# Rezoning Transportation Analysis

Petition Number: #2021-256

Date	Description
04-12-2022	First Review (AO)
08-22-2022	Second Review (AO)
01-25-2023	Third Review (TM)
03-22-2023	Fourth Review (DR)
04-20-23	Fifth Review (TM)

G. Park Site

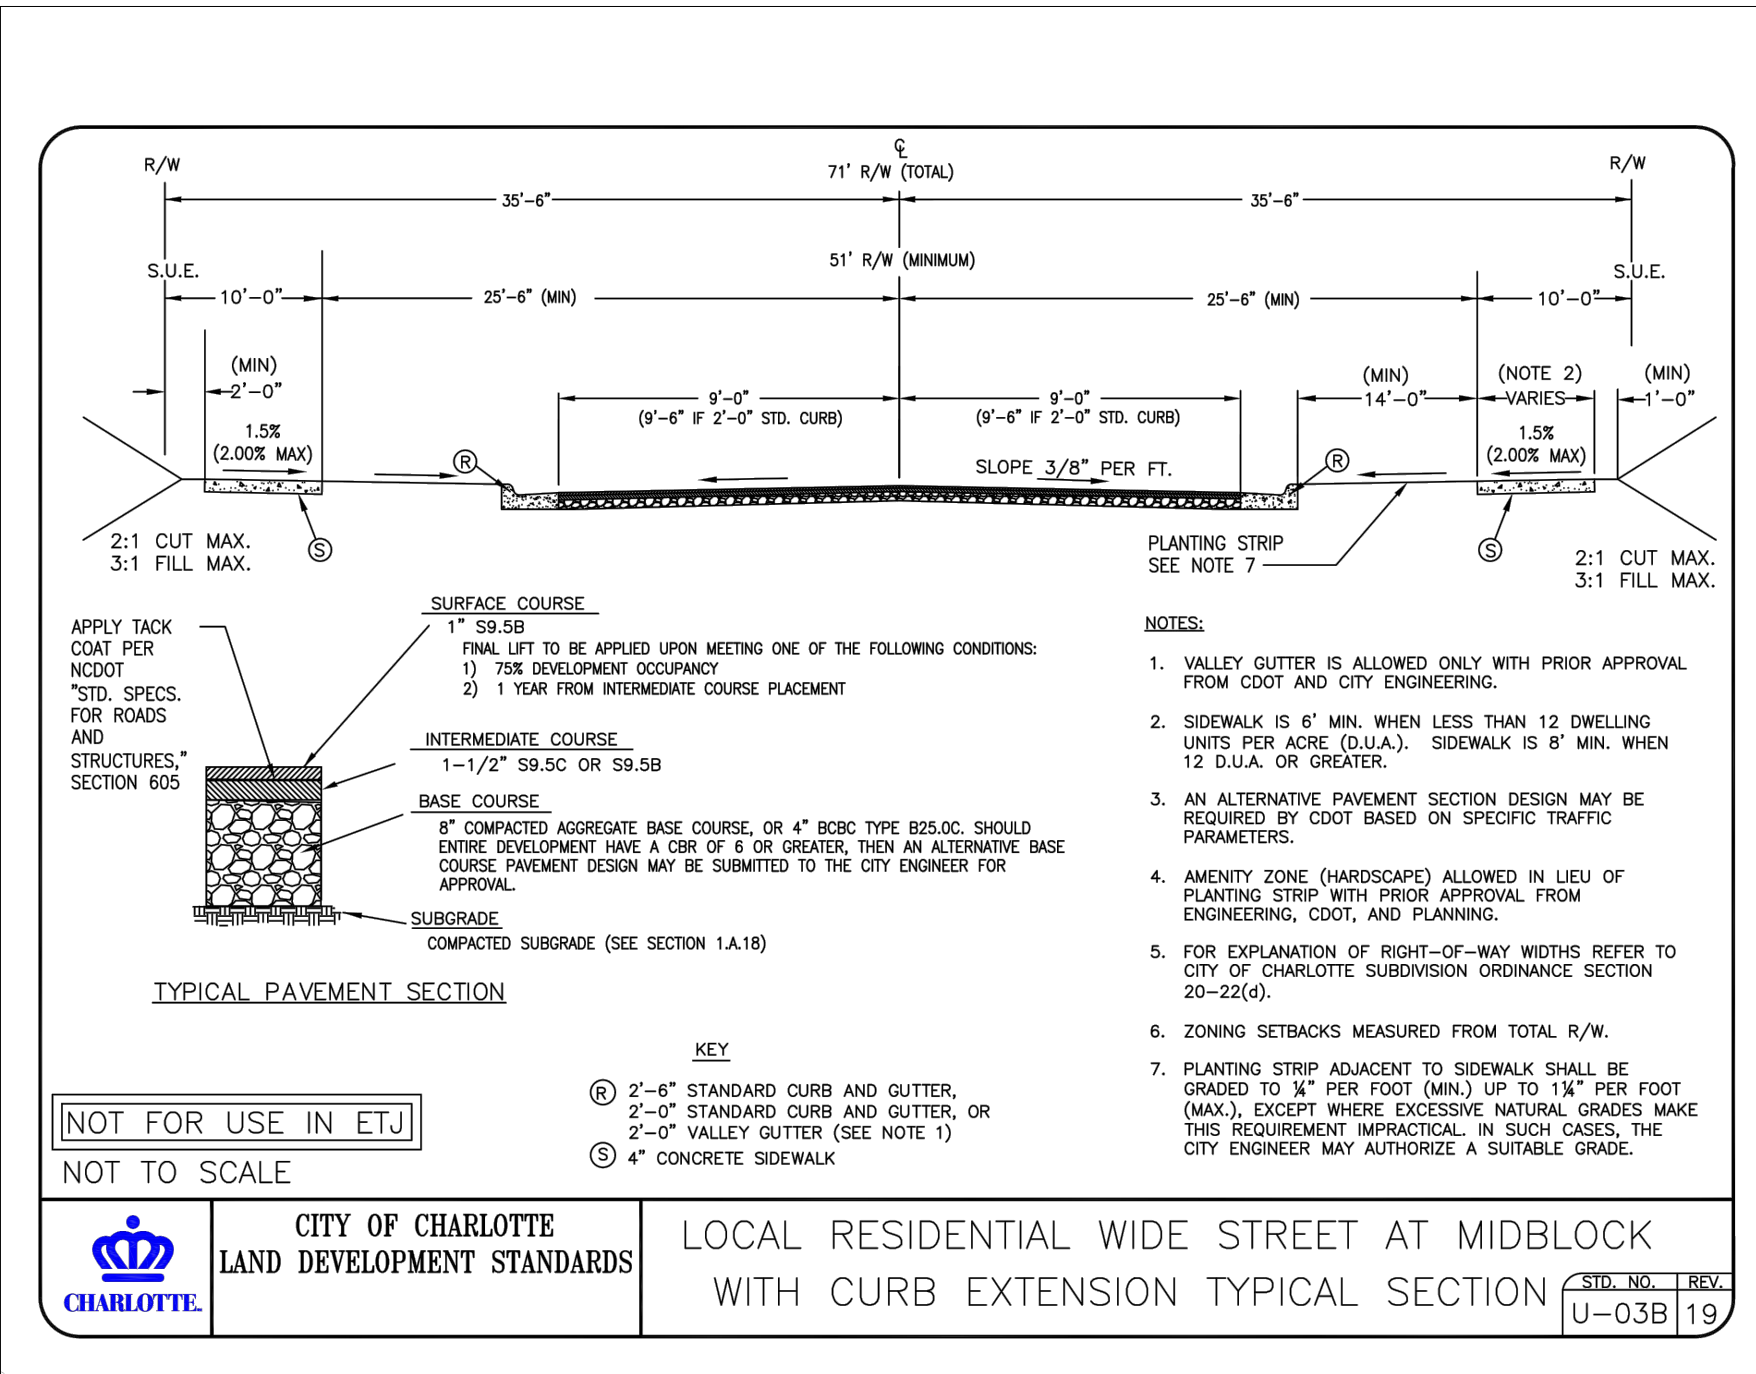
3. **New Comment 4-20-23:** Update conditional transportation notes to include the TIS improvement of installing flashing yellow arrow signal heads for all left turn movements at the intersection of Old Concord Road and Orr Road.

4. **New Comment 4-20-23:** Remove note 9 stating petitioner shall not be required to construct off-site improvements.

9. In the event that there is not existing right of way for any required off-site transportation improvement, Petitioner shall not be required to construct such off-site transportation improvement. However, in such event, Petitioner shall pay to CDOT an amount equal to the cost to install (exclusive of the cost of the right of way) the relevant off-site transportation improvement in lieu of constructing the same.
